CITY OF PORTLAND, MAINE
Department of Building Inspection

Certificate of Occupancy

LOCATION 118 Shepherd Lane (Lot #15) 351-A-030

Date of Issue 22 February 1996

FOUNDATION PLAN
SCALE: 1/4" = 1'-0"

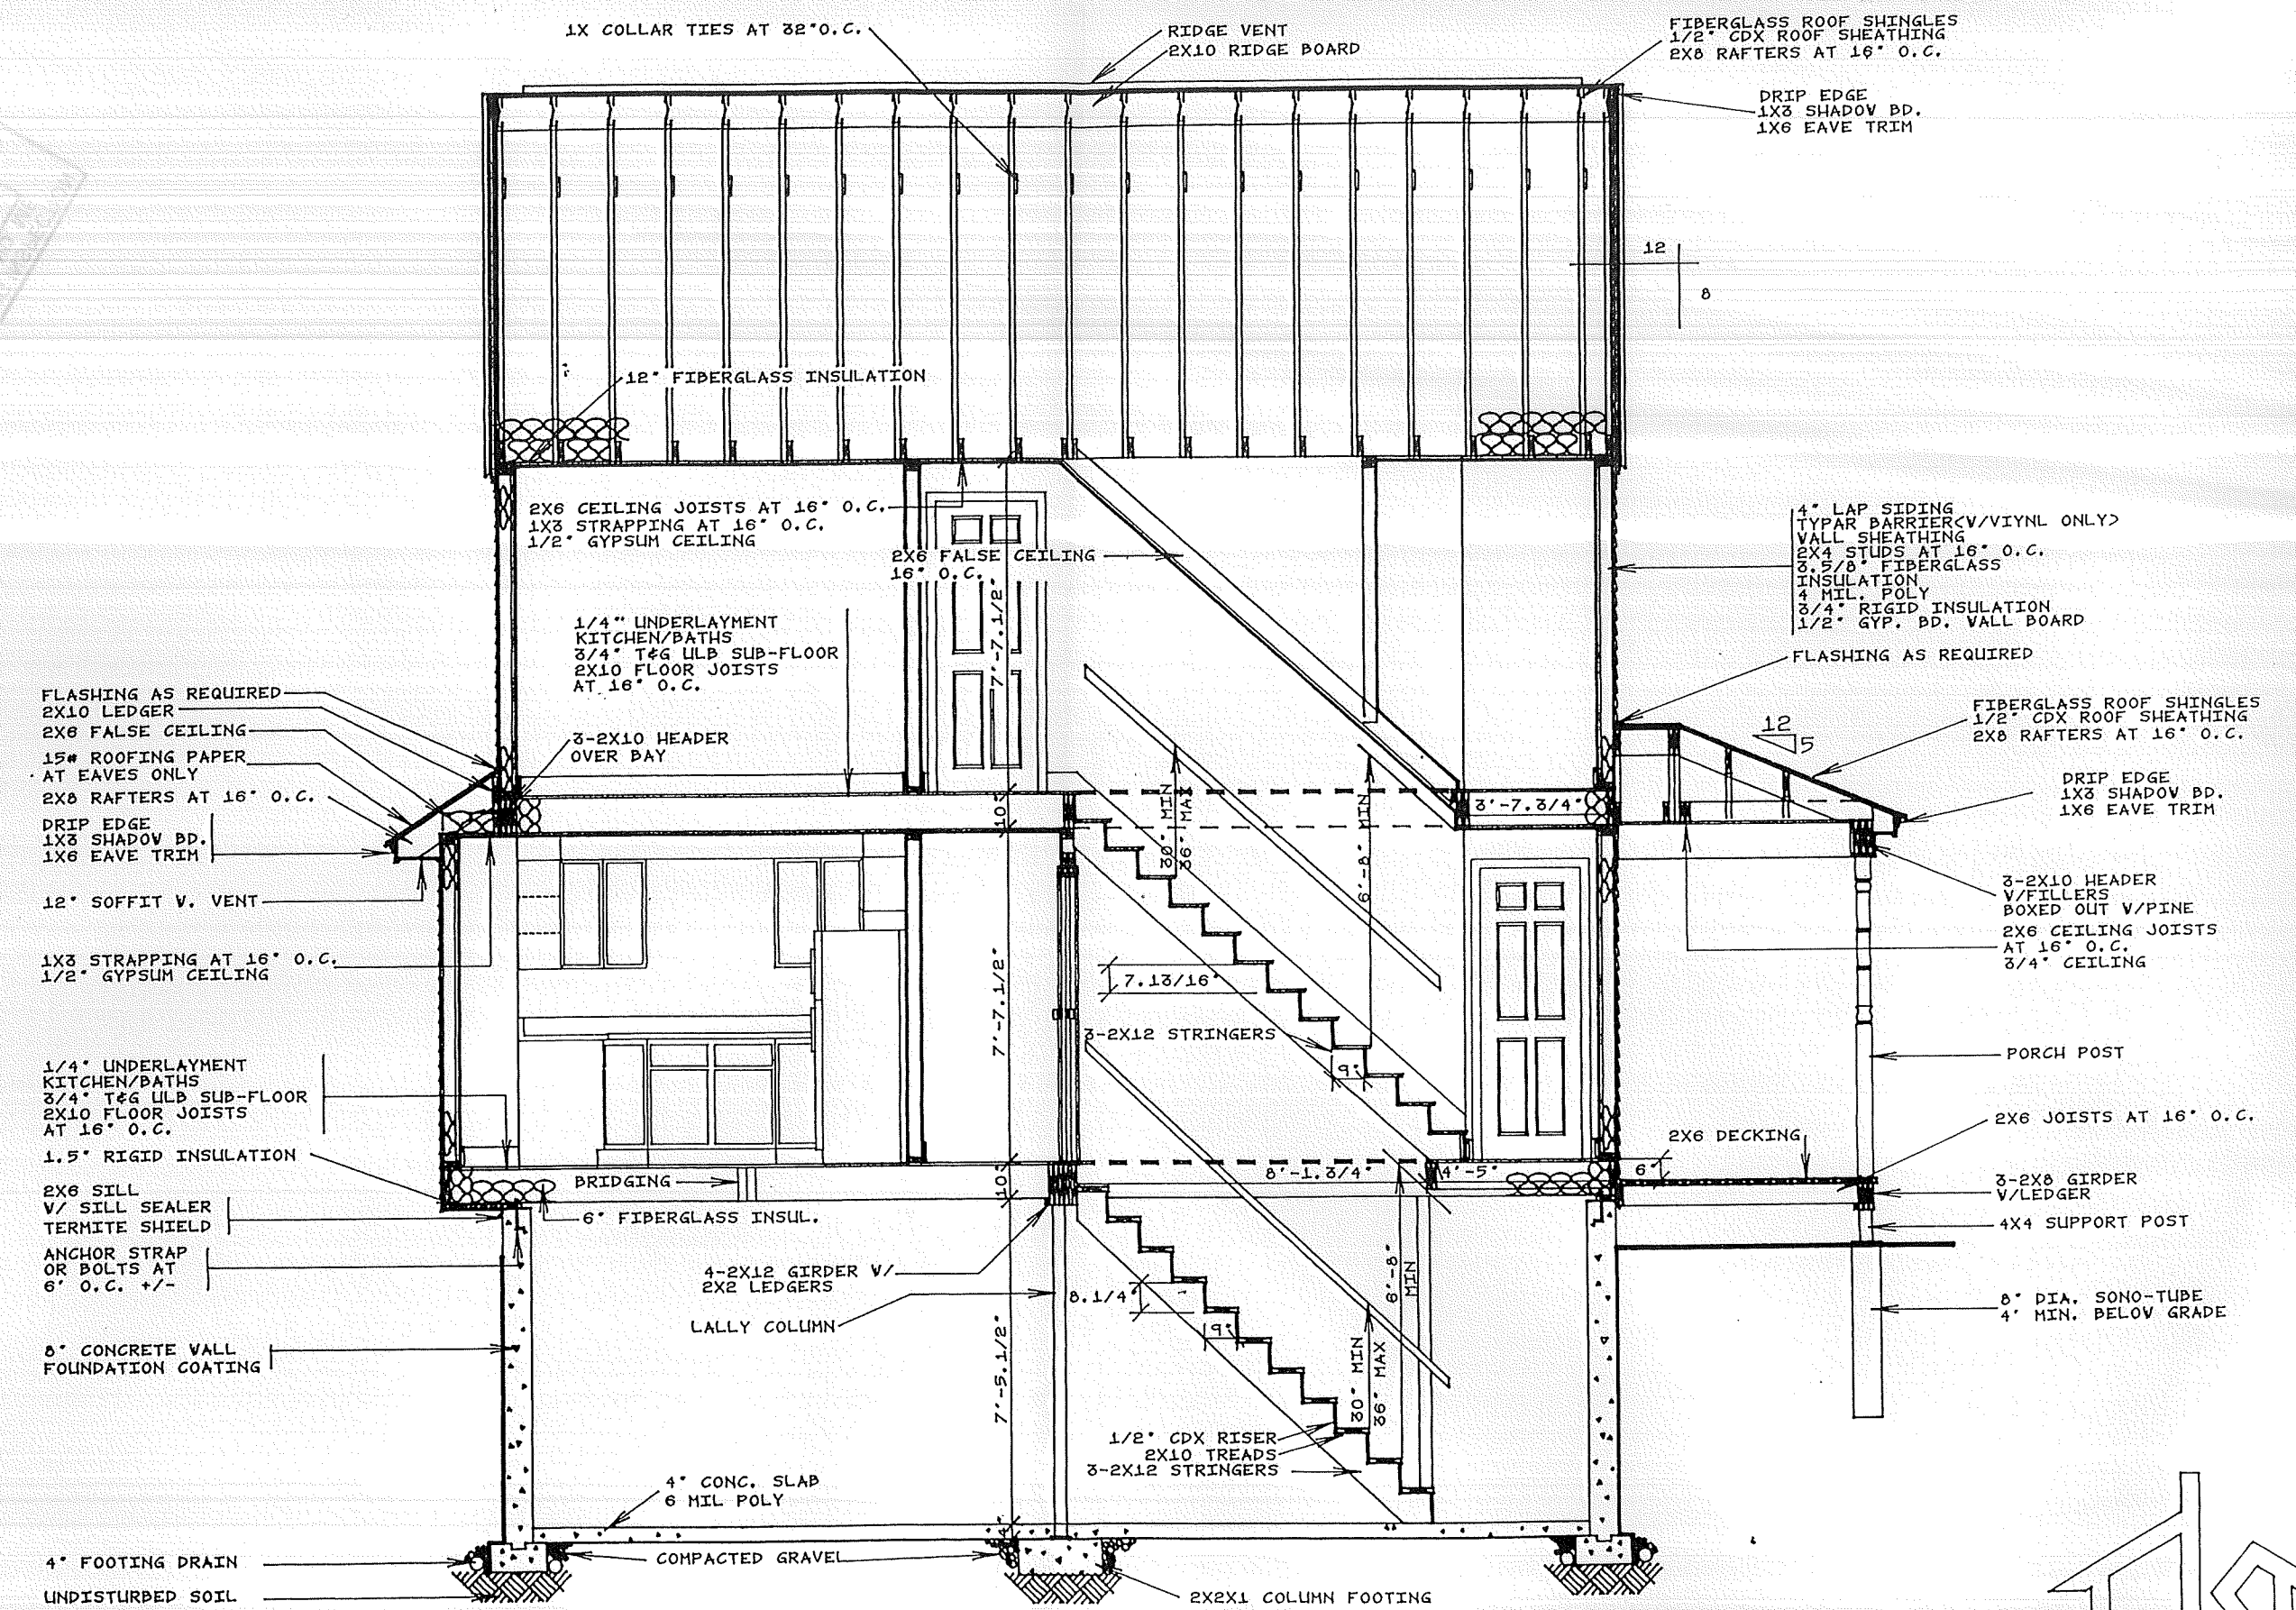
1. See memo dated 21 February 1996 from James Seymour to David Jordan listing three (3) conditions of approval.
2. Sonotubes on front porch must line up with support legs.
3. Side stair platform must have sonotubes (none at time of inspection).
4. Install permanent stairs by 30 June 1996 at rear sliders.

CROSS SECTION
 SCALE: 1/4" = 1'-0"

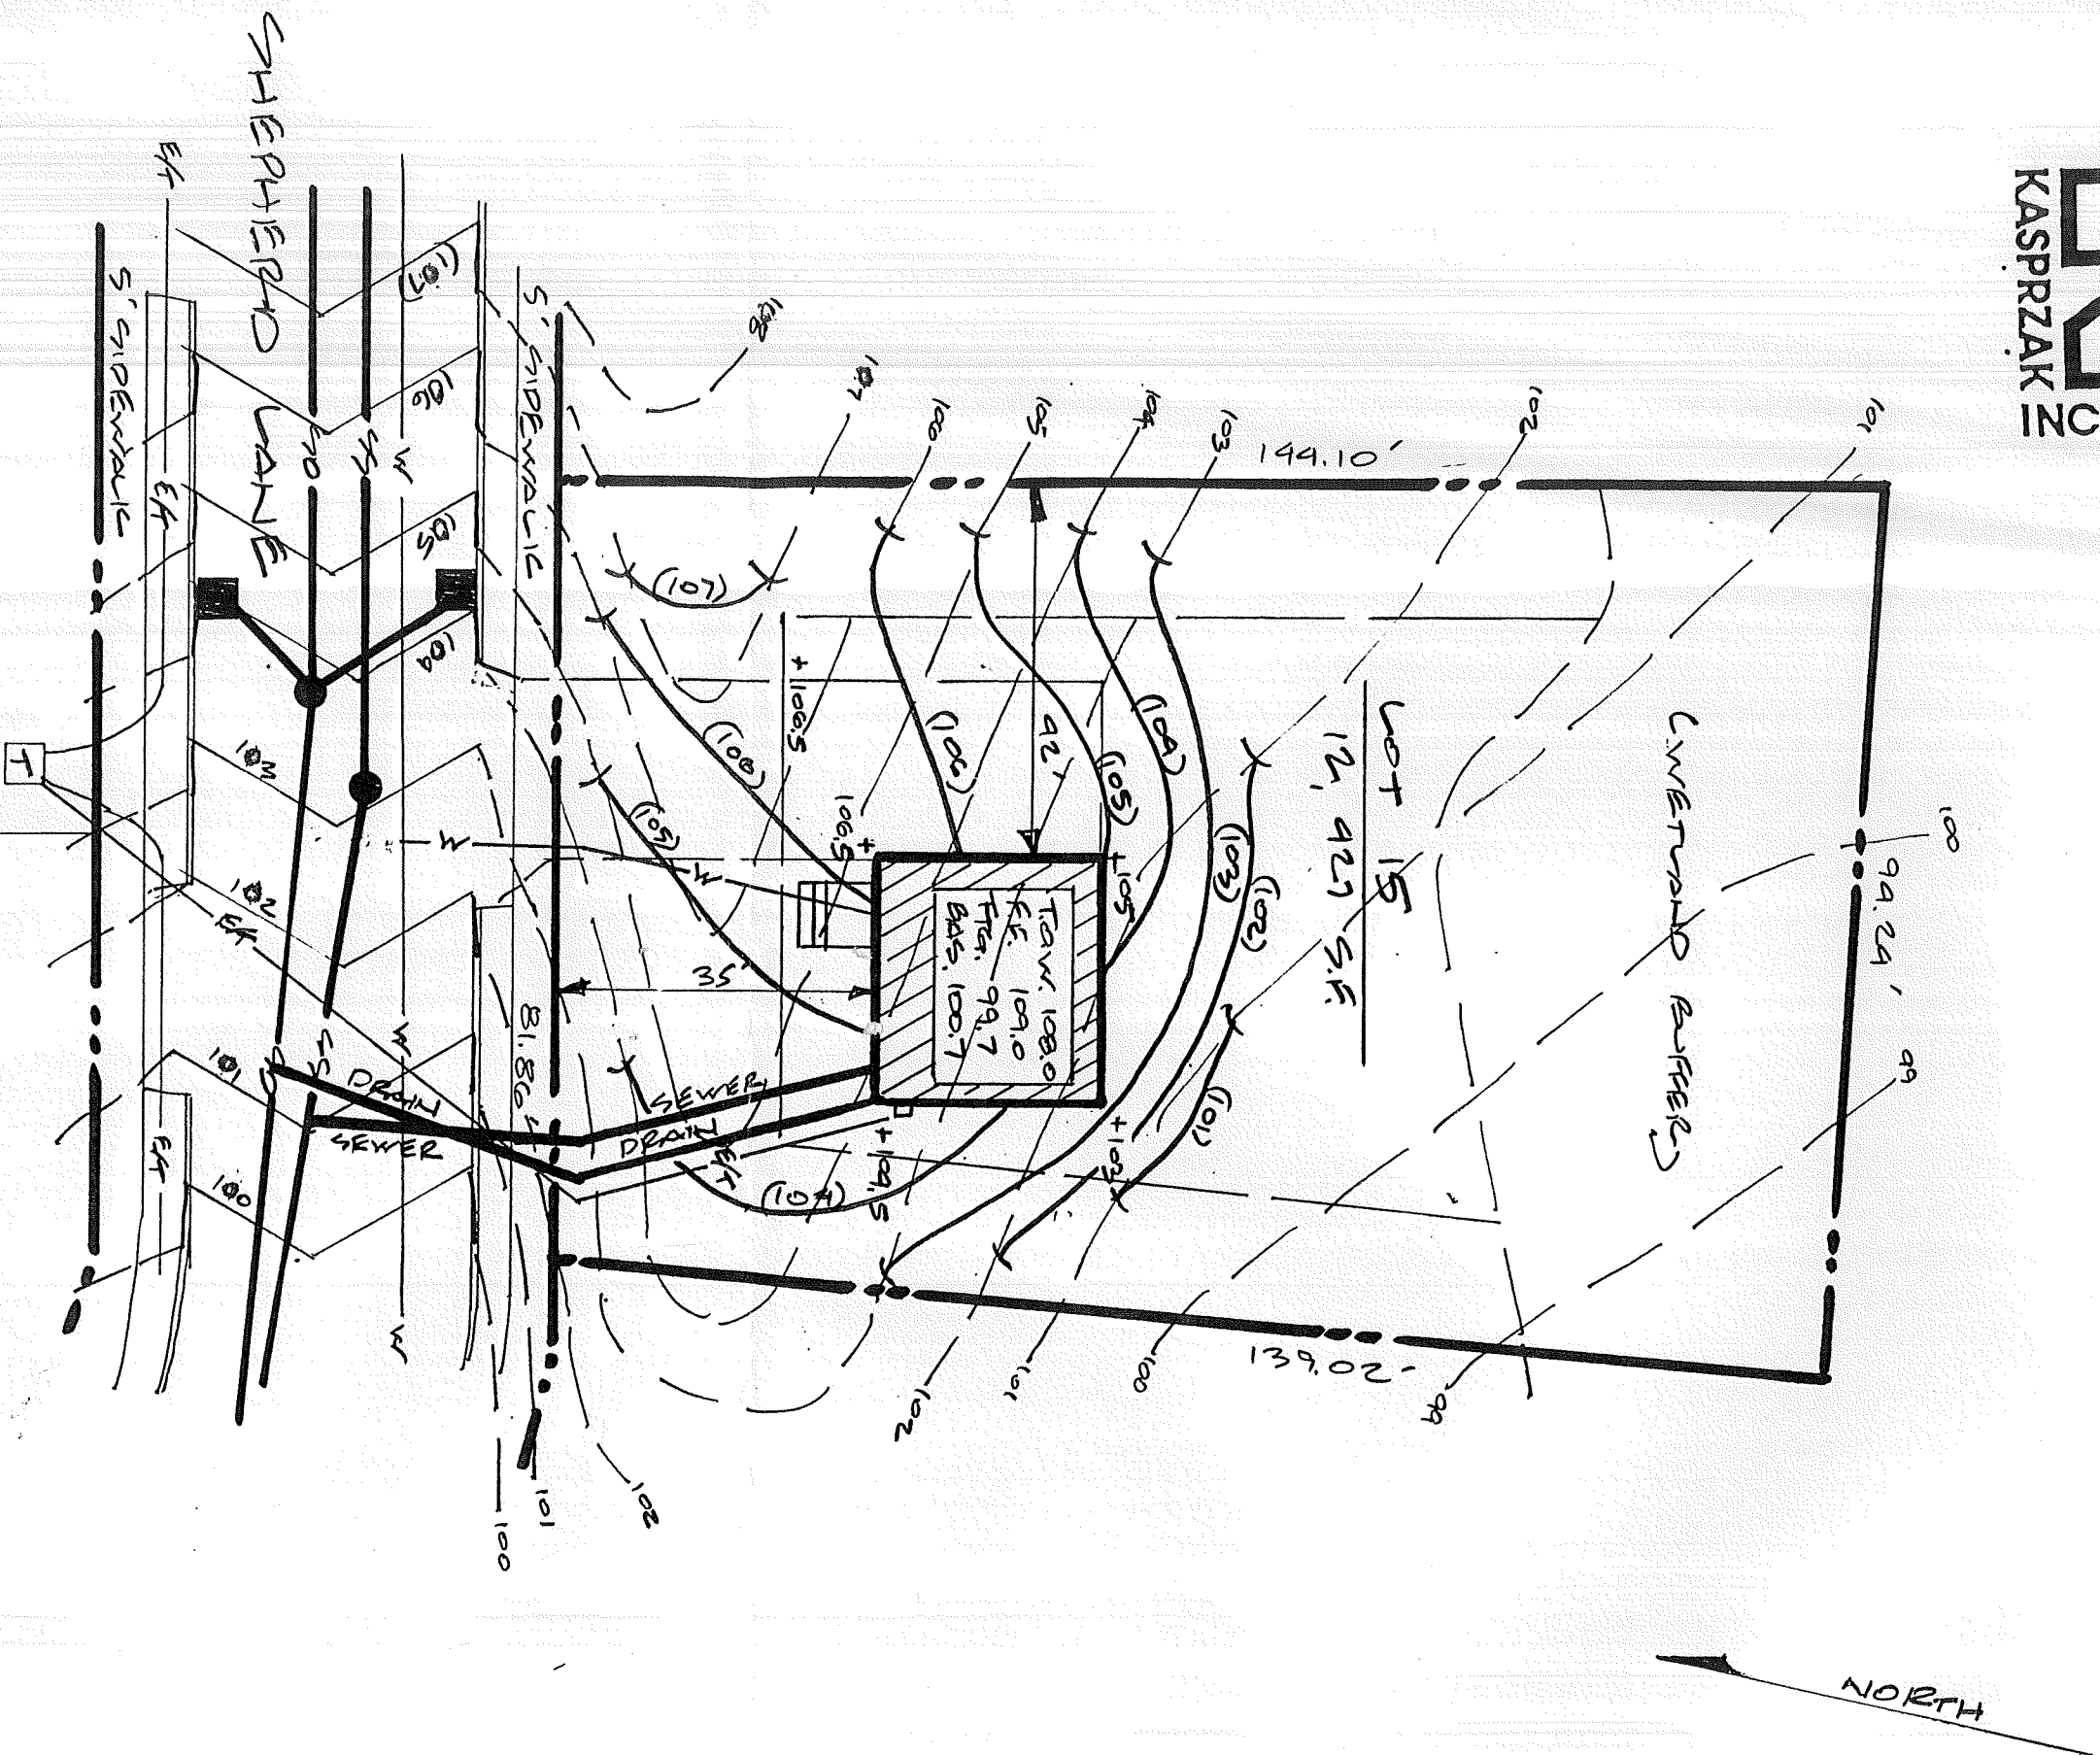
1. The disturbed lot areas shall be winter hay mulched following the guidelines set forth by the Best Management Practices (BMP's) published by the Maine DEP, as soon as weather permits and approved by the Development Review Coordinator. Final grass vegetation of the lawn areas shall be in place by April 24, 1996. The applicant shall monitor areas to be grassed and will be responsible to vegetate or reseed areas as is necessary to accomplish the above condition.

3. Siltation fencing shall be installed at the limit of construction and reviewed by the Development Review Coordinator. The siltation fence shall be properly toed and secured by either a date when ground surface becomes unfrozen enough to install fencing or a date no later than April 1, 1996. Siltation fence may be removed once areas disturbed by construction have become 80% revegetated.
